# CITY OF ALBUQUERQUE

December 1, 2022

**RE: MDS - Montage Subdivision Unit 7 on Bobby Foster  
Grading and Drainage Submittal for Preliminary Plat and Grading Permit  
Grading Plan Engineer's Stamp Date: 7/13/22  
Drainage Report Engineer's Stamp Date: missing  
Hydrology File: R16D100A**

TITLE: HYDRAULIC ANALYSIS MONTAGE 7 - MESA DEL SOL			
Design Review Committee	City Engineer	Mo./Day/Yr.	Mo./Day/Yr.
Last Update			
City Project No.	Zone Map No.	Sheet	OF EXHIBIT 2

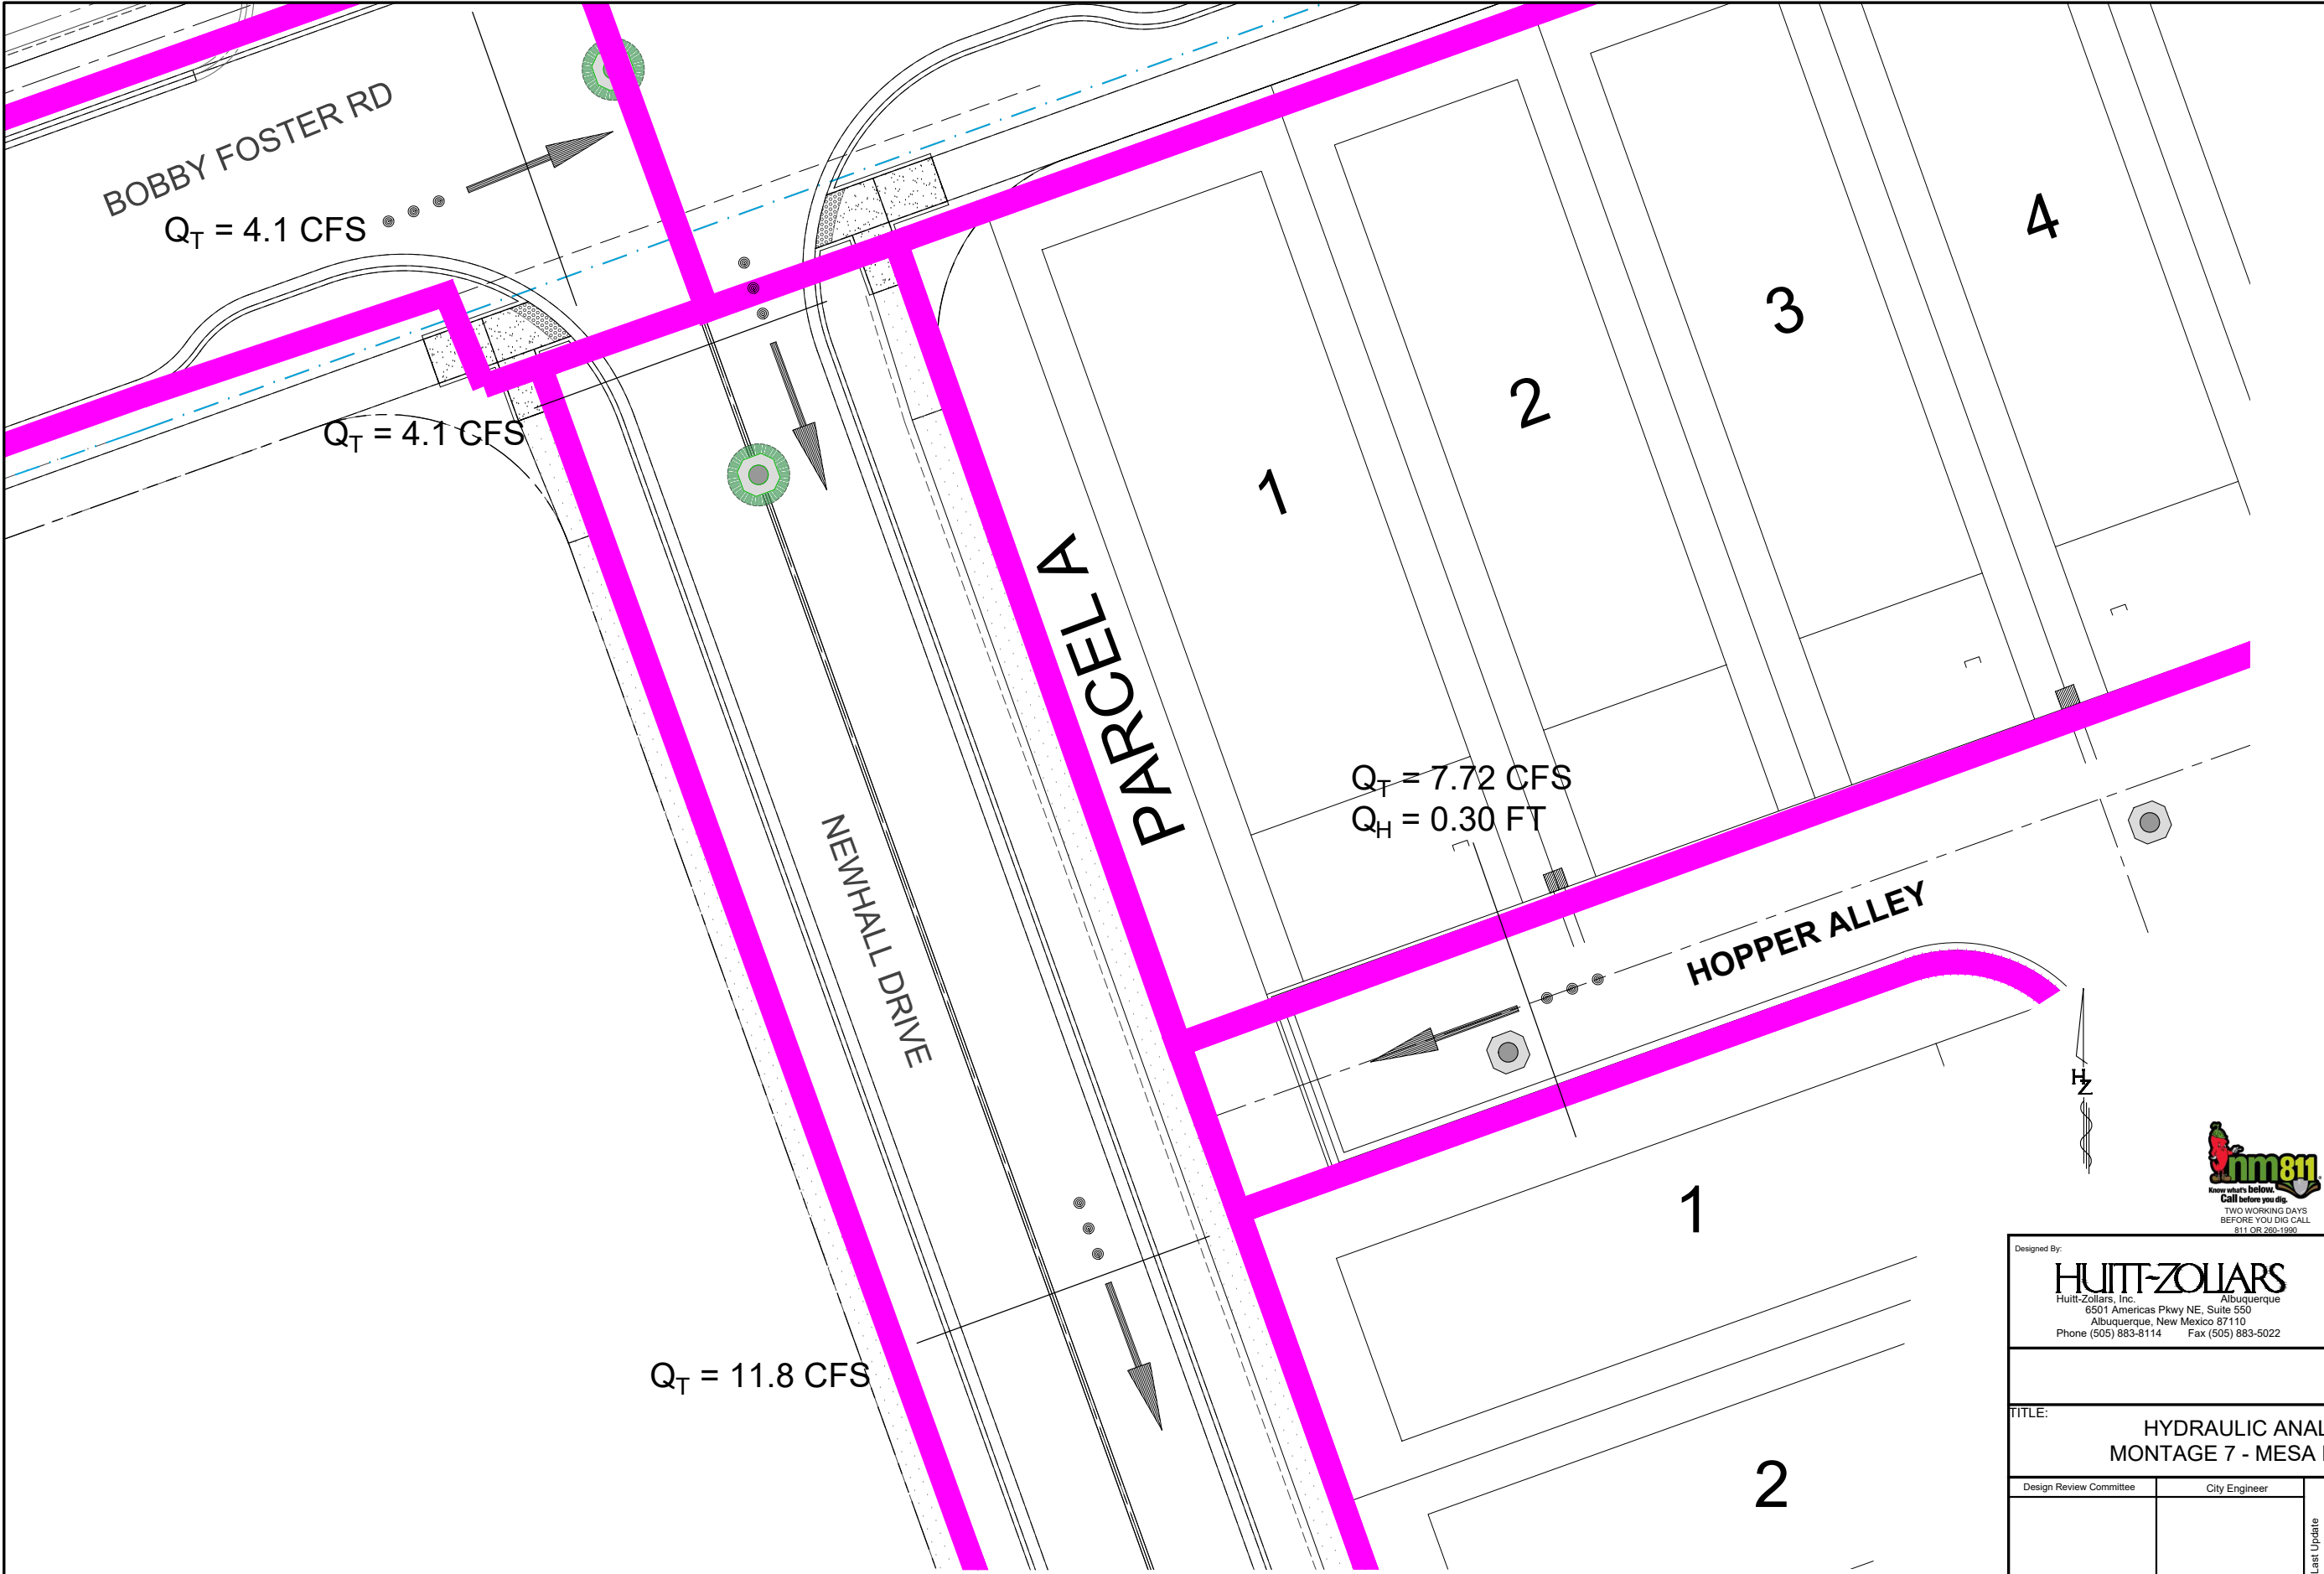
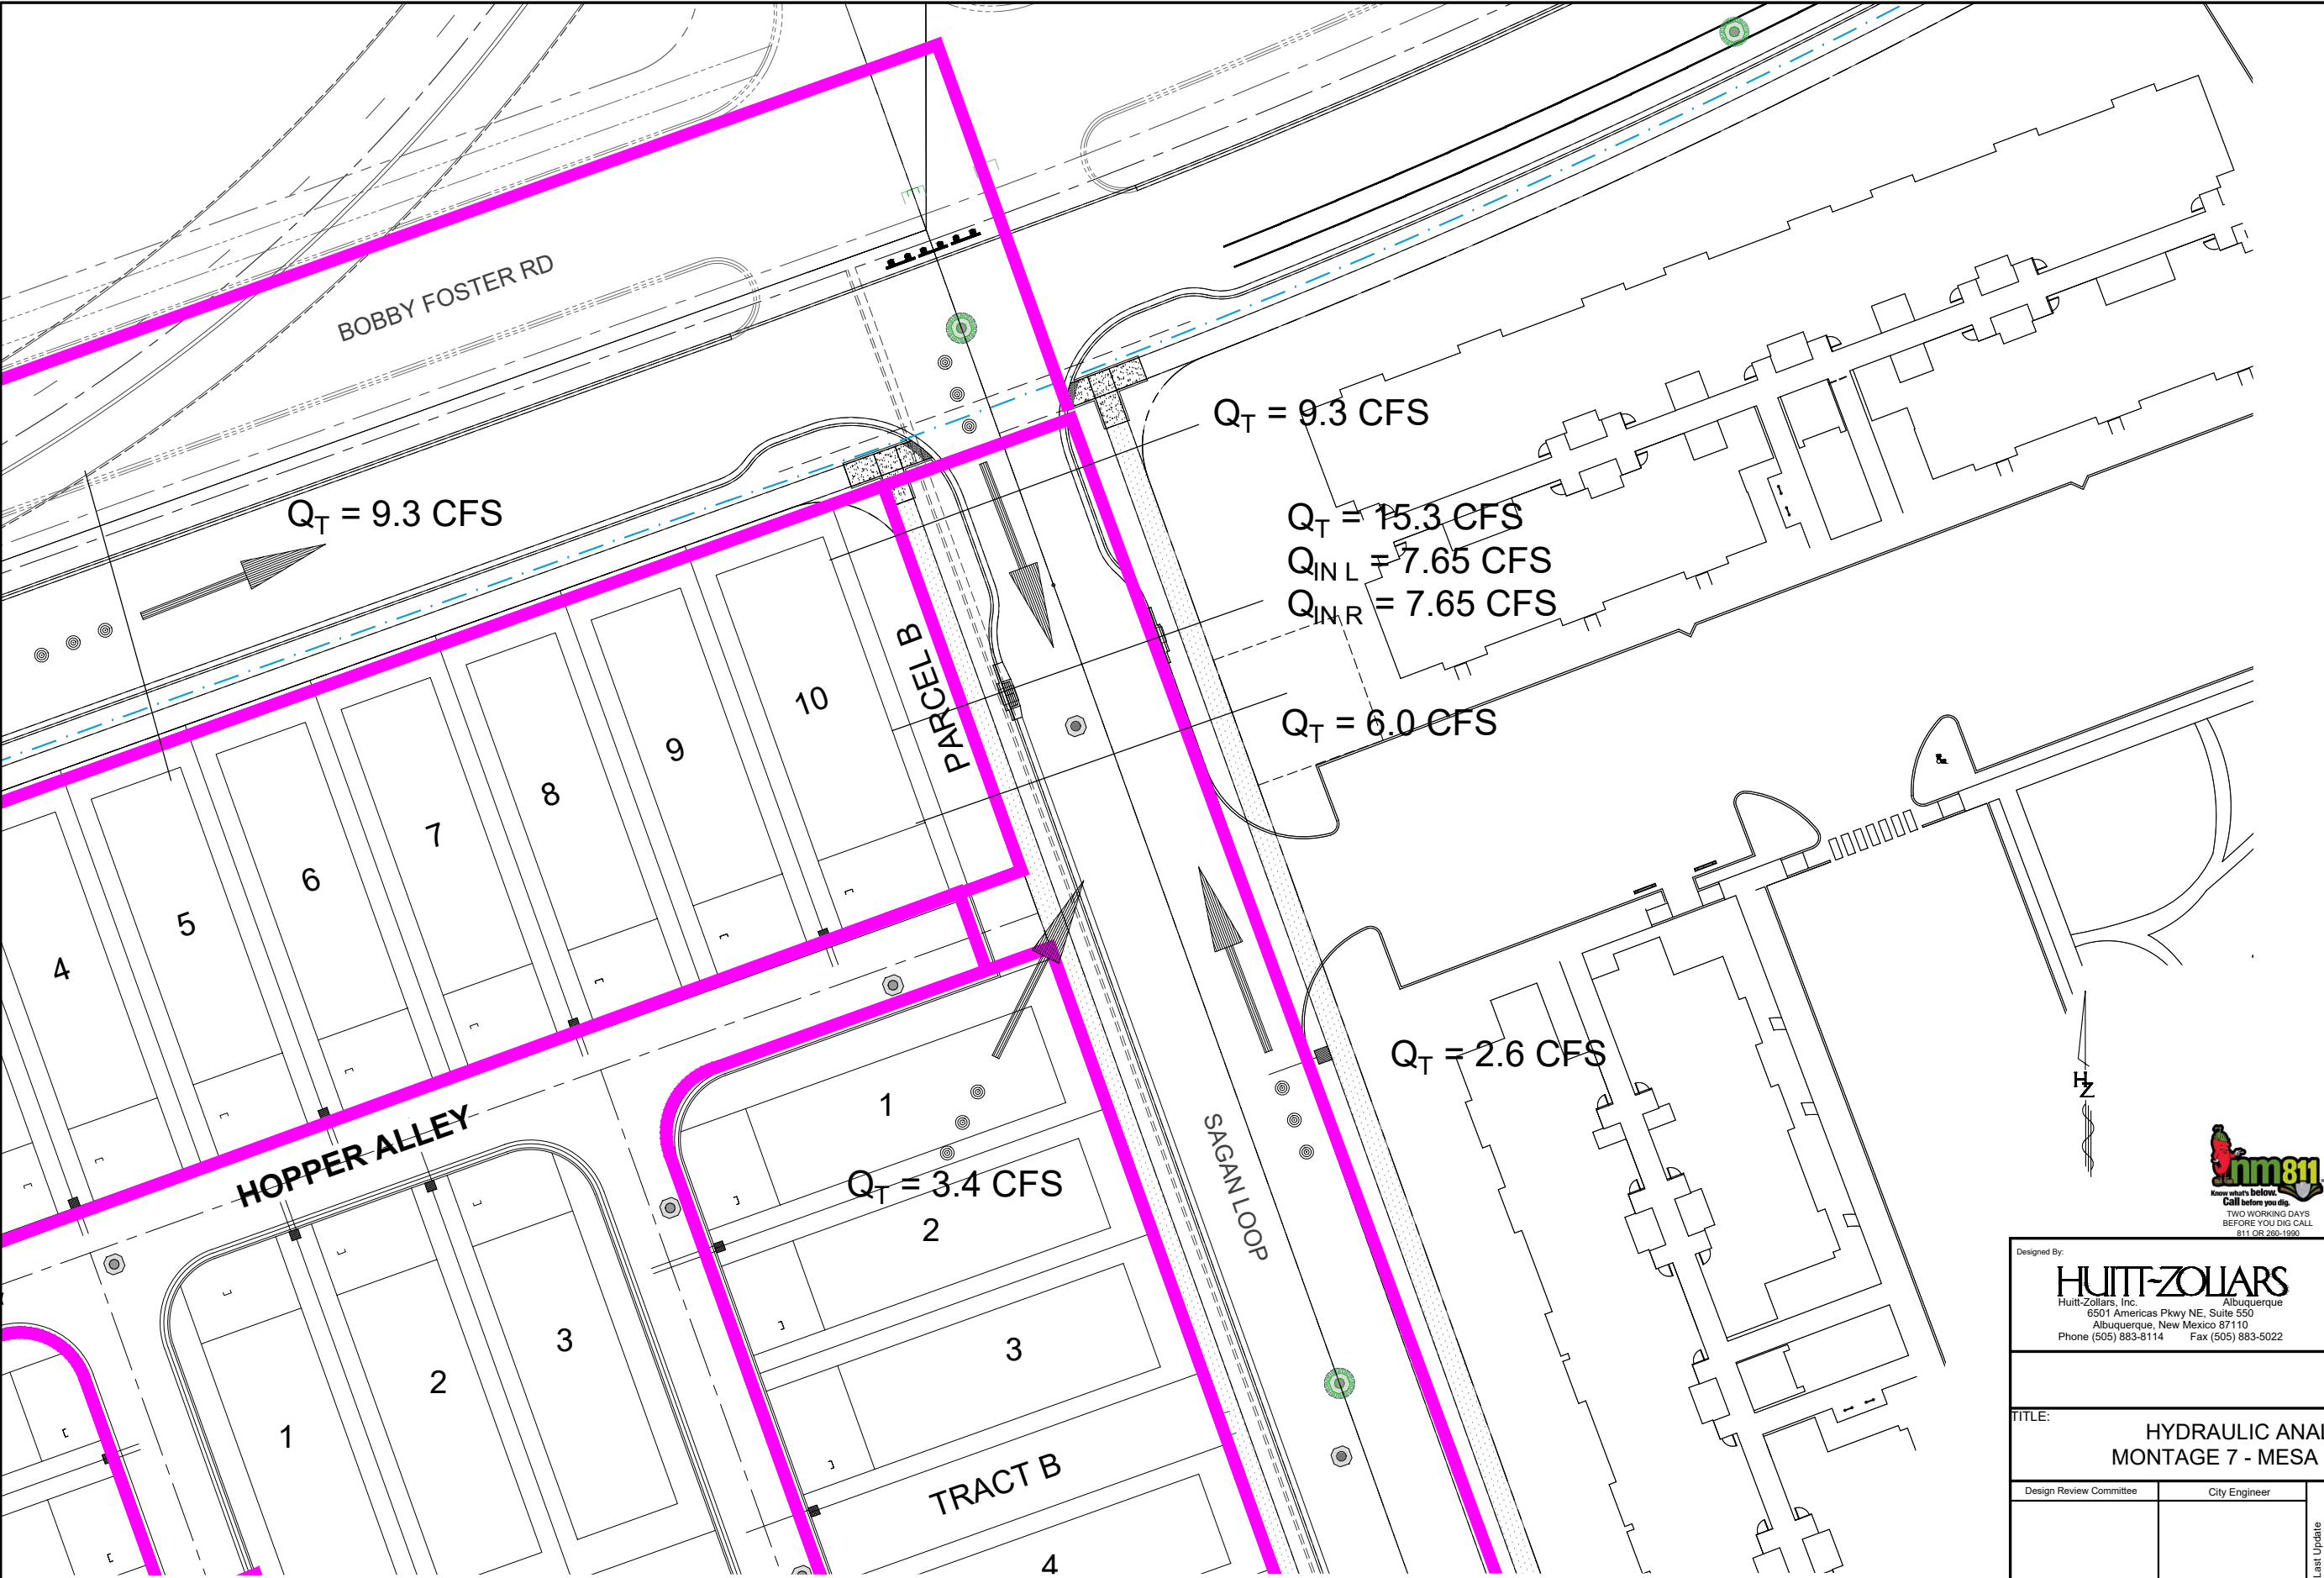
Provide surface drainage analysis demonstrating that the 100-year HGL remains at/below top of curb, and the 100-year EGL remains within the ROW for the onsite streets and alleys and the adjacent streets that receive drainage from this site per DPM 6-9(A).

7. StormCAD is used in the Montage Unit 7 Report but insufficient information has been provided to show that it meets DPM requirements. Hydraulic calculations must be performed along the Energy Grade Line using the Bernoulli Equation, per the DPM. The calculations presented in HEC-22, 3rd Edition agree with the DPM but the earlier editions (1st and 2nd) do not use Bernoulli's correctly. The City of Albuquerque-Hydrology Section accepts the manhole loss methodology presented in HEC-22, 3rd Edition, section 7.1.6.7 and rejects the two methods prescribed in HEC-22, 1st Edition and 2nd Edition. StormCAD v8i SELECTseries5 (build 08.11.05.58) and later, by Bentley, is acceptable provided that the calculations are performed using HEC-22, 3rd Edition and the user selects the "Energy Grade" option for losses. Provide detailed input and output files to demonstrate compliance with the DPM.  
The flow rates in the pipes must be supported by inlet interception rates which are based on 100-year flow depths and velocities in the streets per DPM procedures for inlets on grade. Hydraulic grade line calculations and pipe profiles will be required prior to drainage report approval for (WO).
